Your ref: SSD 5041 MOD 3
Our ref: MC 11-2620/2

Re: SSD 5041 MOD 3 – Kings Park Metal Recovery, Processing and Recycling Facility

ATTACHMENT A

Figure 4 | Proposed Modifications to the Approved Site Plan

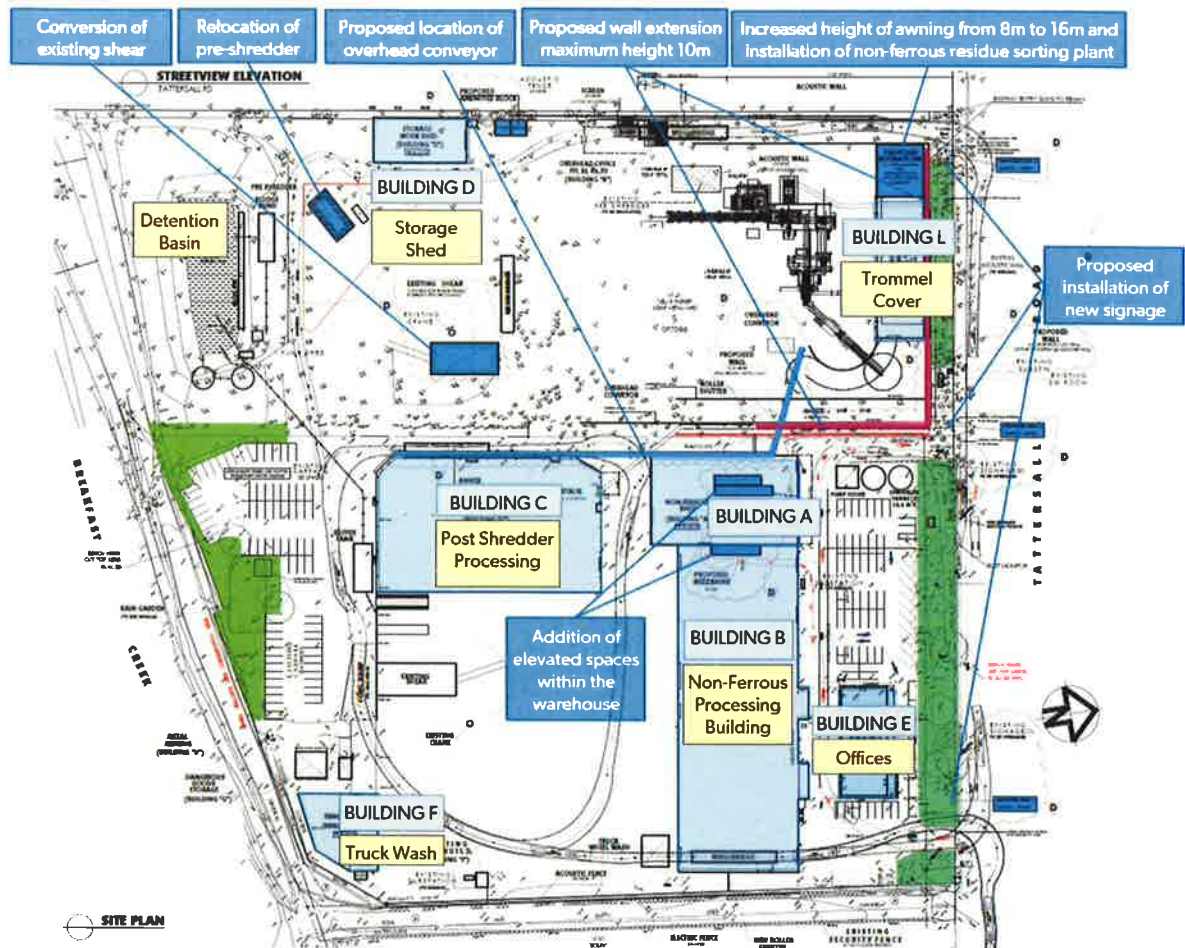
- i. The site plan indicates that 3 signs at gates A, B and C are proposed to be constructed in our nature reserve along Tattersall Road. This is not supported and all signs are required to be constructed wholly within the property boundary.
- ii. Additional car parking is required to be provided for the additional commercial floor space proposed within buildings A & B. The rate to be applied is 1 space per 40 square metres in accordance with Part A, Clause 6 Car parking of Blacktown Development Control Plan 2015.
